Client	TII NTA	Project	METROLINK	Drawing Title	METROLINK - STRUCTURES CHARLEMONT STATION PROPOSED STREET LEVEL DESIGN	Drawing Status	S0
Consultant	JACOBS IDOM	Drawing N°	ML1-JAI-SRD-ROUT_XX-DR-Z-02090	Plan Drawing N°	ML-ST 307 O-A1		
		Scales Original Size A1	1:250			Sheet	1 of 6

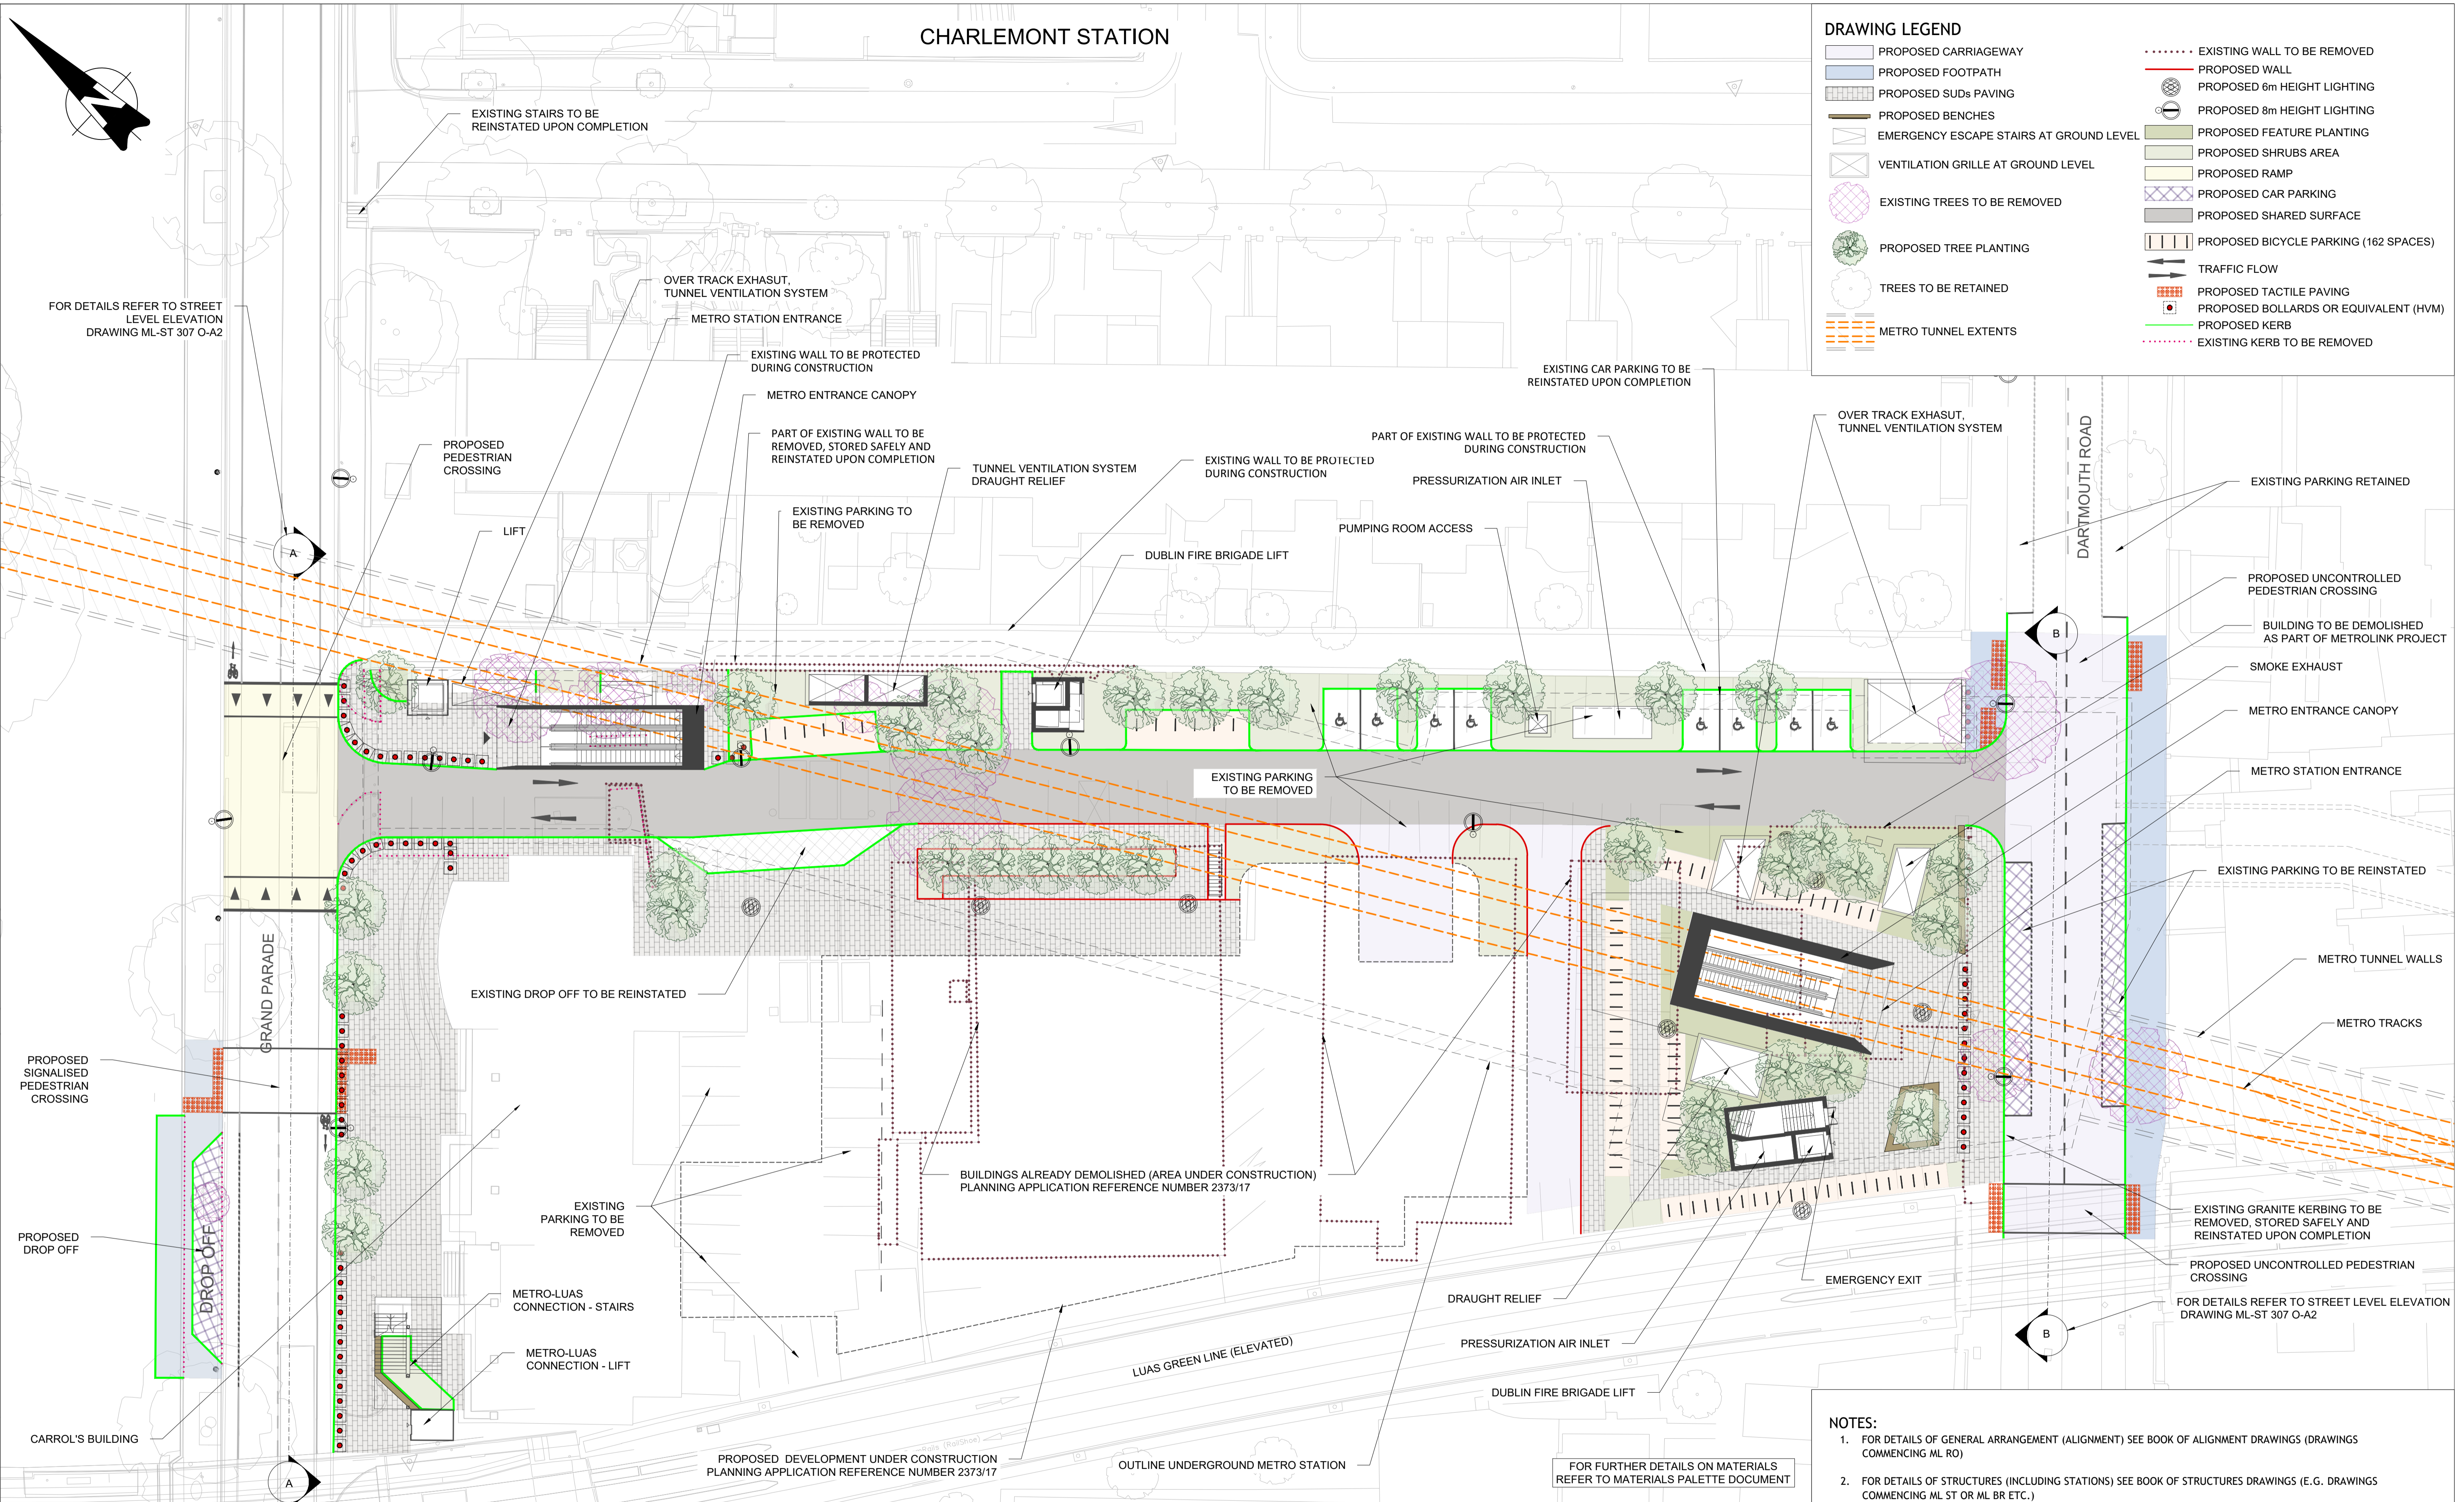
7	Letter	3	7) It is noted that the proposed Metrolink is capable of carrying 20,000 people per hour IN EACH DIRECTION: if the Metrolink terminates at Charlemont, there is a very narrow warren of streets around it and the barrier of the canal with narrow footpaths which makes dissipation of large throngs problematic : if the terminus were at St Stephen’s Green, there are many possible options - Luas, buses, taxis etc.	<p>The rationale for locating the southern MetroLink interchange at Charlemont rather than St Stephen's Green is explained by response (1) above.</p> <p>With particular regards to the pedestrian comfort in the vicinity of the proposed Charlemont Station. A microsimulation VisWalk model has been developed for the immediate area surrounding Charlemont Station during the operational phase. The model covers the full extent of the publicly accessible station area, including the immediate vicinity of the station entrance at street level, the Luas stop and nearby junctions at Charlemont Bridge. In order to accommodate the forecast demand from the proposed Charlemont Station, a new staircase with 2.4m stair width is proposed at the south east corner of Charlemont Luas stop. An elevator will also be provided at this location. Both are sized for MetroLink to Luas, and Luas to MetroLink passenger numbers.</p> <p>In addition, it is proposed that the pedestrian crossing on R111 Grand Parade will be repositioned to the front of the building being developed by Hines. With this infrastructure in place, the model indicates that the R111 Grand Parade will have an acceptable level of service overall, with some reductions in service seen at the pedestrian crossing where pedestrians are required to wait for a green phase at the signals. Overall, it is considered that the model displays an acceptable level of network performance.</p> <p>The proposed pedestrian crossing on Grand Parade will have minimal impact on the traffic flow along Grand Parade and can be programmed to operate in sync with the existing signalized junction at Grand Parade /Charlemont Street to maintain the flow of traffic movements. When the Project is operational, car mode share will decrease, with a reduction of up to approximately 830 car tips to and from the zones surrounding Charlemont Station over the 12hr period in 2065. In overall terms, the Charlemont Station will provide for improvements to the public transport network resulting in decreases in private car usage/trips, increases in public transport usages and will facilitate walking and cycling to the station, without significantly impacting on the operation of the road network in the area.</p> <p>Furthermore, TII have deliberately designed the Station with minimum set down space (with the exception of a drop-off on Grand Parade for persons of restricted mobility only) or room for taxi ranks so that it does not encourage the Station to be used as a terminus.</p>

Submission No.			34	
Organization Name or Name of Submitter			Caitriona Shaffrey (18 Dartmouth Square, Ranelagh)	
Item No.	Section Ref.	Page No.	Observation Statement	TII Response
Re: Railway (MetroLink-Estuary to Charlemont via Dublin Airport) Order 2022 Case Reference Number NA29N.314724 10 th January 2023				
8	Development	3	8) The draft development plan appears to be a well-balanced plan which seeks to create thriving communities all around the city, each with their own characteristics: this proposal which seeks to drop a major hub into a residential area without developing the ancillary facilities such as cafes, shops and public open space. It is not clear how the boundary with the former Carroll's building will be handled - whether it will be secured at evening times which would segregate the area further .	<p>The draft development plan falls outside of the scope of the MetroLink Project and the remit of TII. The proposed MetroLink Station at Charlemont has been integrated with the public realm, however the wider development of the area is a matter for Dublin City Council.</p> <p>As set out by EIAR Chapter 4, Description of the MetroLink Project, section 4.17.12.2 "The Charlemont station is an underground cut and cover station with two public access points, located beside and integrated with an adjacent development (currently under construction). It has surface connectivity to the Luas Green Line along Grand Parade and has two entrance/exits from the station, one onto Grand Parade and one onto Dartmouth Road. The Grand Parade exit provides connectivity to the Luas stop with additional path width provided between the two modes of transport. The site is also characterized by the presence of the Carroll's Building, which is an office building completed in 1964 and listed on the DCC Record of Protected Structures. A landscape avenue of trees and low-level planting segregates pedestrians from the road, creating a safer environment for pedestrian movement in this area. The path widths and circulation routes are improved between the entrance and a Luas stairs and access lift on the western side of the Charlemont Luas stop. The second exit/entrance onto Dartmouth Road has a public plaza integrating seating, raised planters, large mature trees and cycle parking. The station box itself sits adjacent to an office development that is within private ownership. The landscape design within this area is coordinated with the development currently under construction and integrated with the infrastructural requirements. The landscape design here consists of pockets of planting and strategically placed mature trees to integrate and soften the human experience within this zone. Parking spaces and cycle parking are also provided here, as well as ramp access to private parking and office basement." (Chapter 4, section 4.17.12.2).</p> <p>The securing of the Carrolls Building is a matter for the owners of the property, however TII can confirm that any securing of the Carrolls property will not limit access to the MetroLink Station. Access will be maintained to both entrances of the Station, including via the access linking Dartmouth Road to Grand Parade.</p>
